About the application

Application number: 2025/93140	
What is the application for?:	Installation of replacement shop front and roller shutter (within a Conservation
Address of the site or building:	Kami Healthcare Ltd, 8, Market Place, Birstall, Batley, WF17 9EL
Postcode:	WF17 9EL

Proposed Front Elevation

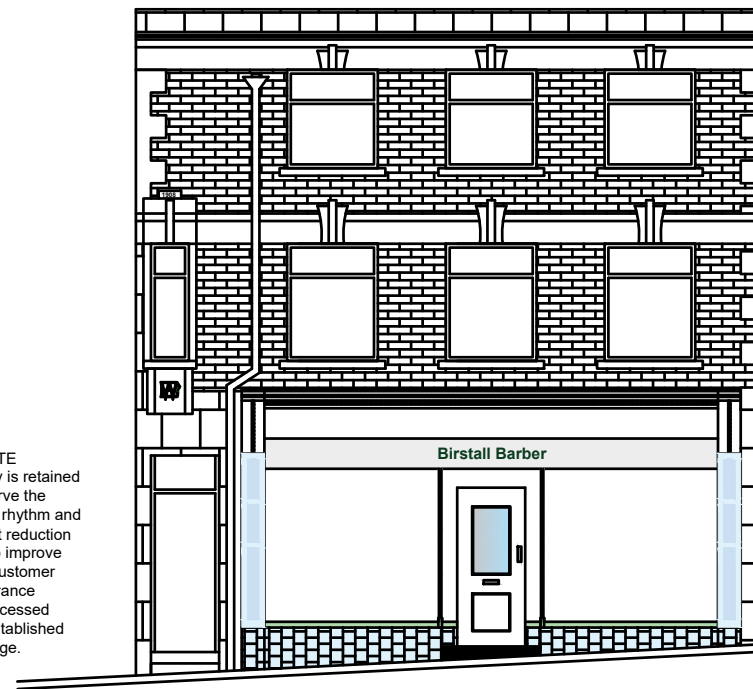
Type of comment: An objection	
Do you wish your comments to be published on the website anonymously?	<input type="checkbox"/> Yes
I don't believe the village of Birstall needs another barber shop, however I'd rather see the shop in use than stand empty, what I object to is the disregard and disrespect to the building front. It's been hacked at and smashed, it needs replacing respectfully as was, keeping it in line with the rest of the traditional shop fronts in the village
